# **OXFORDSHIRE COUNTY COUNCIL'S RESPONSE TO CONSULTATION ON THE FOLLOWING DEVELOPMENT PROPOSAL**

**Application no:** 15/01068/F

**Proposal:** Erection of two storey extension to existing hotel to form 62 new bedrooms (60 net increase)

**Location:** Bicester Golf And Country Club Akeman Street Chesterton Bicester Oxfordshire OX26 1TE

Drawing Title:
 Pond & discharge detail

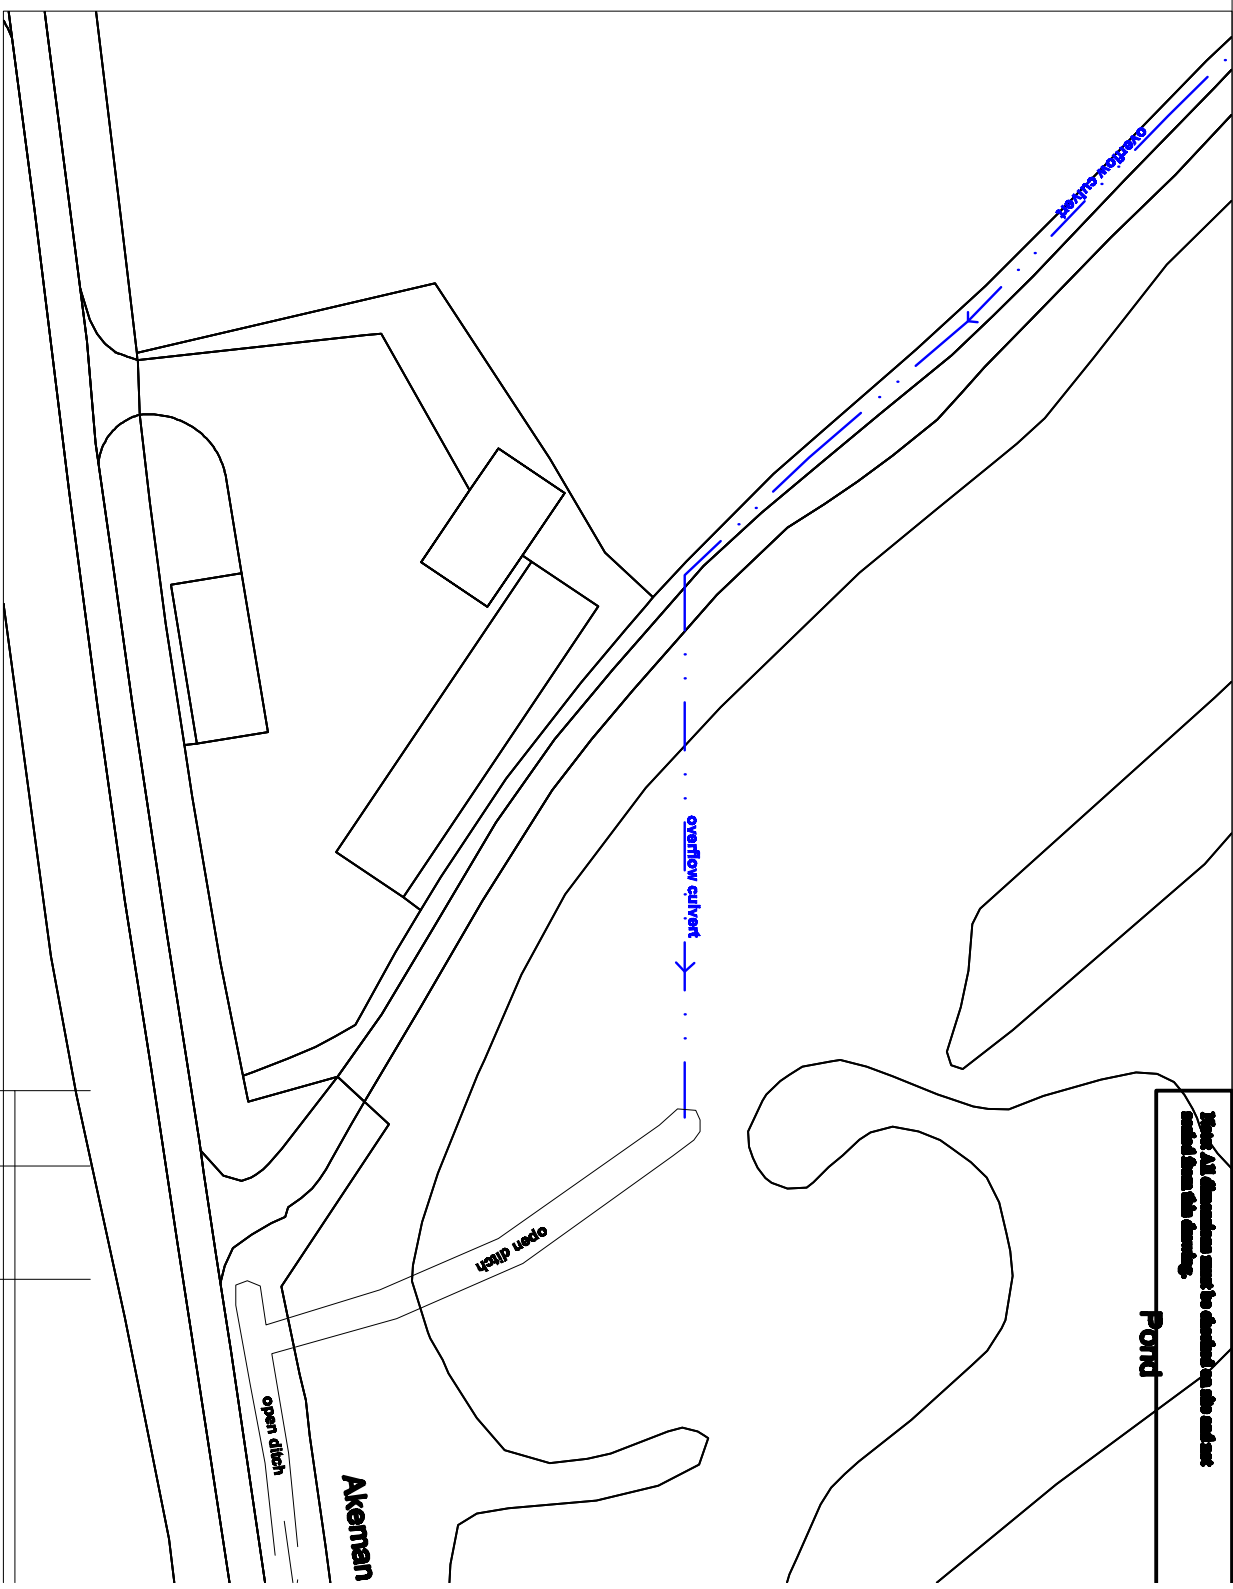
The application form states that a pond is being used to drain the proposed buildings surface water. Information is required on how this will be done and calculations need to be carried out ascertain whether there is sufficient capacity in the pond.

The current documentation does not contain any information regarding surface water drainage and is therefore not acceptable in its current form. An assessment of the surface water drainage will be required.
